From: Martin Gillam [REDACTED]
Sent: 09 July 2020 08:43
To: Anita Gardner <Anita.Gardner@arun.gov.uk>
Subject: CM/16/20/PL

I see that the architect has submitted some additional information regarding the redesign of house type F1. This looks to be an effort on their side to show that the new design has a similar roof height to the approved design.

Drawing Title:
HOUSE TYPE-F1
ELEVATIONS

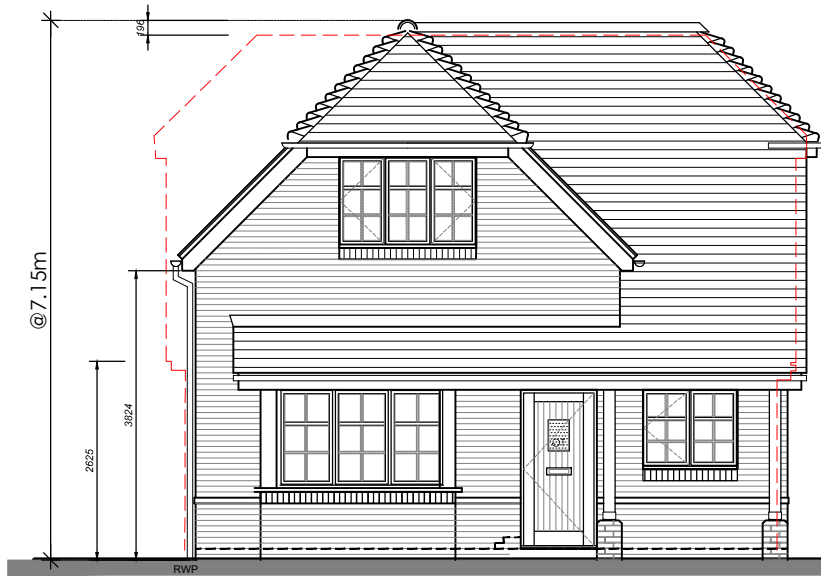
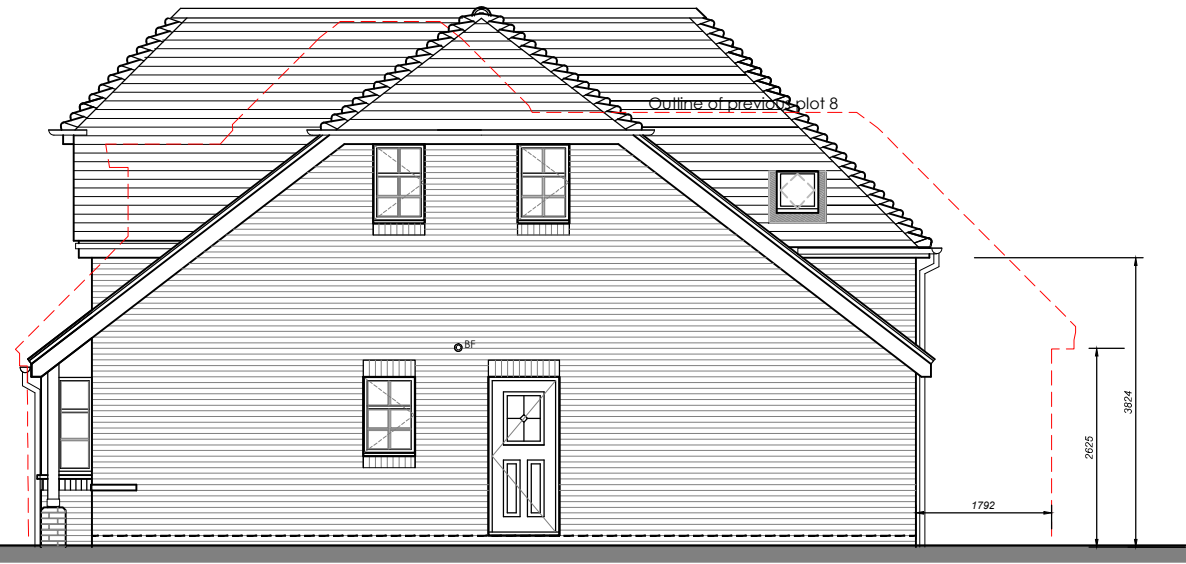
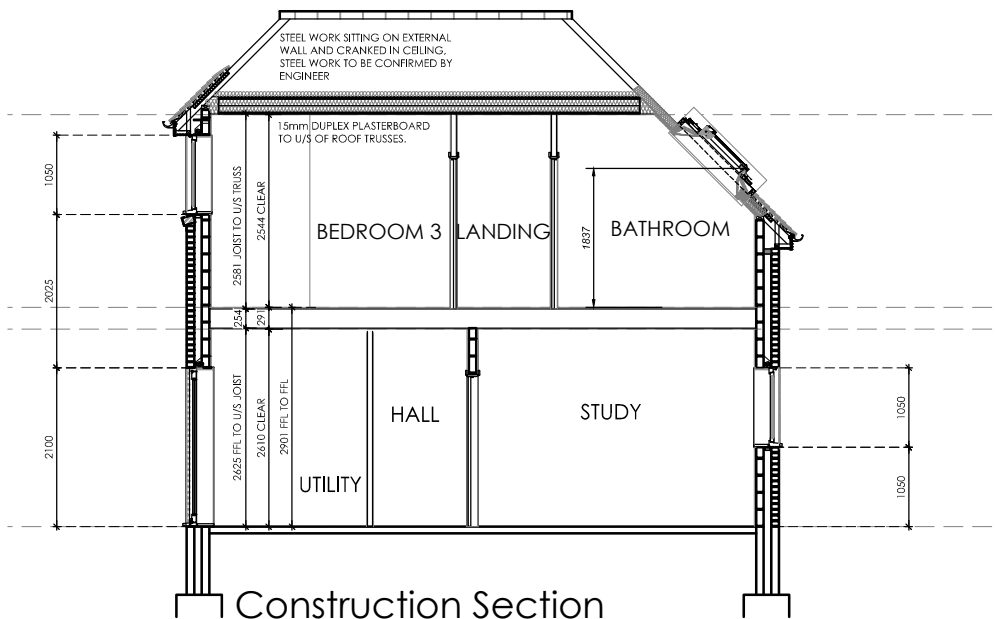
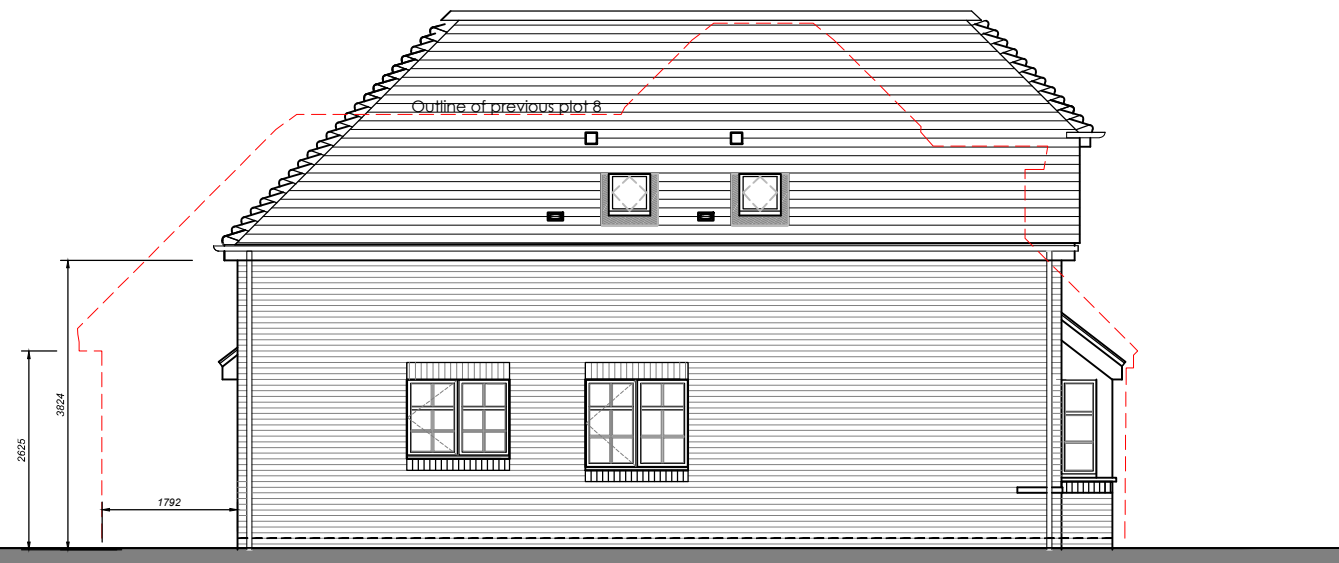
The approved design is a chalet bungalow with a flat roof. Clearly this will be lower and less overshadowing than the two story 7.1m high plans they have re-submitted. Both plans have the same width (7832mm), therefore the elevations of the two properties can be shown to be drawn to the same scale. Overlapping the side elevations clearly shows that the red dotted lines on the redesign elevations are drawn incorrectly.
